## **Application by Longfield Solar Energy Farm Limited for an Order Granting Development Consent for the Longfield Solar Farm project.**

### **The Examining Authority's Additional Written Questions and Requests for Information (ExQ3)**

#### **Issued on 1 December 2022**

FIGURE TITLE  
Illustrative Concept Design

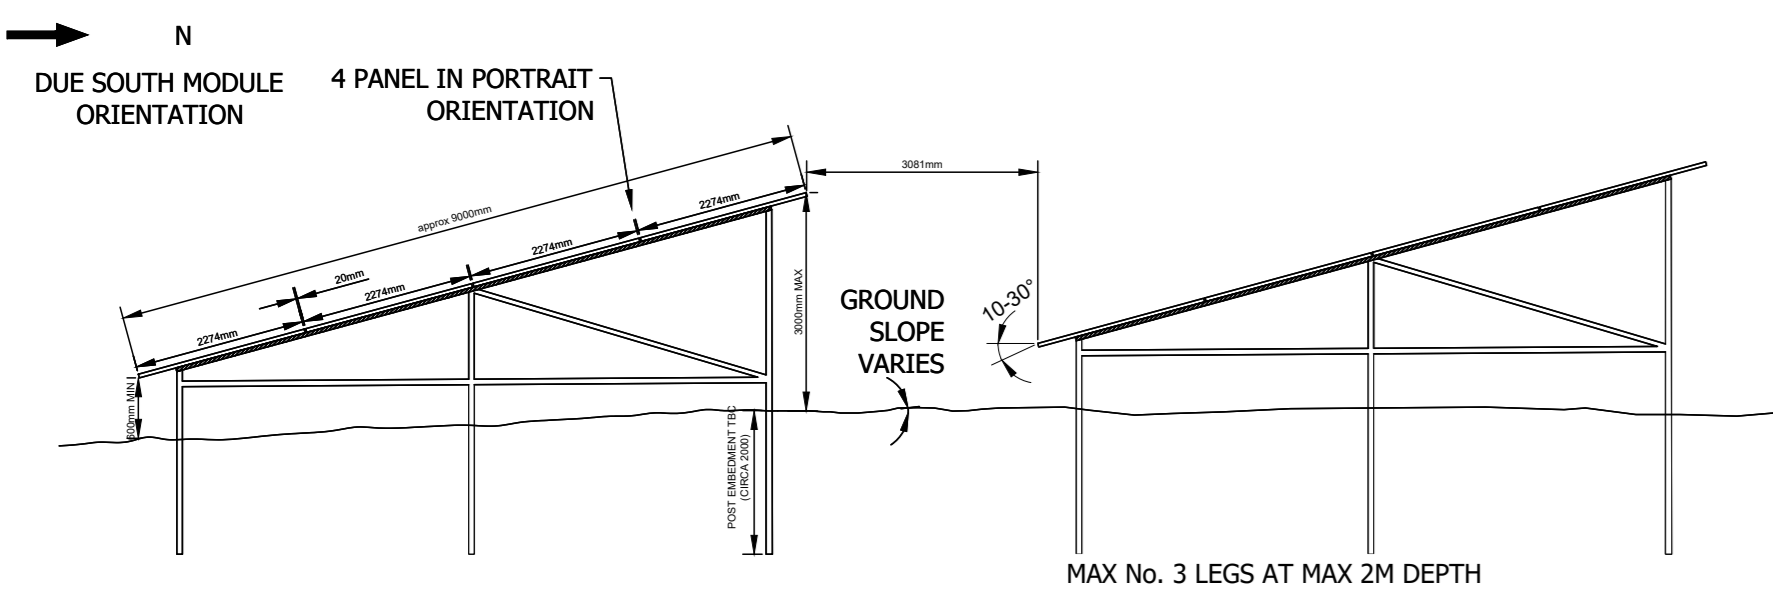
3.2.3	Braintree District Council	<p>The ExA notes that ES Figure 2-5 (Illustrative Concept Design/Operational Layout Overview) [REP3-041] and ES Figure 10-15 (Vegetation Removal Plan) [REP5-006] have been updated to reflect the micro-siting of the track to avoid the RPA of the veteran tree (T9). The ExA also notes that the oCEMP has been updated [REP4-014] to incorporate additional mitigation.</p> <p>Please indicate whether or not the Council considers any further mitigation is required in relation to veteran trees.</p>

ExQ.	Respondent:	Question:
3.2.4	Applicant	The ExA notes that the 'Legend' contained in the Illustrative Concept Design [REP3-041] contains an error in relation to the identification of individual trees (the green colouring appears to have been deleted). Please review and provide an updated document into the Examination.
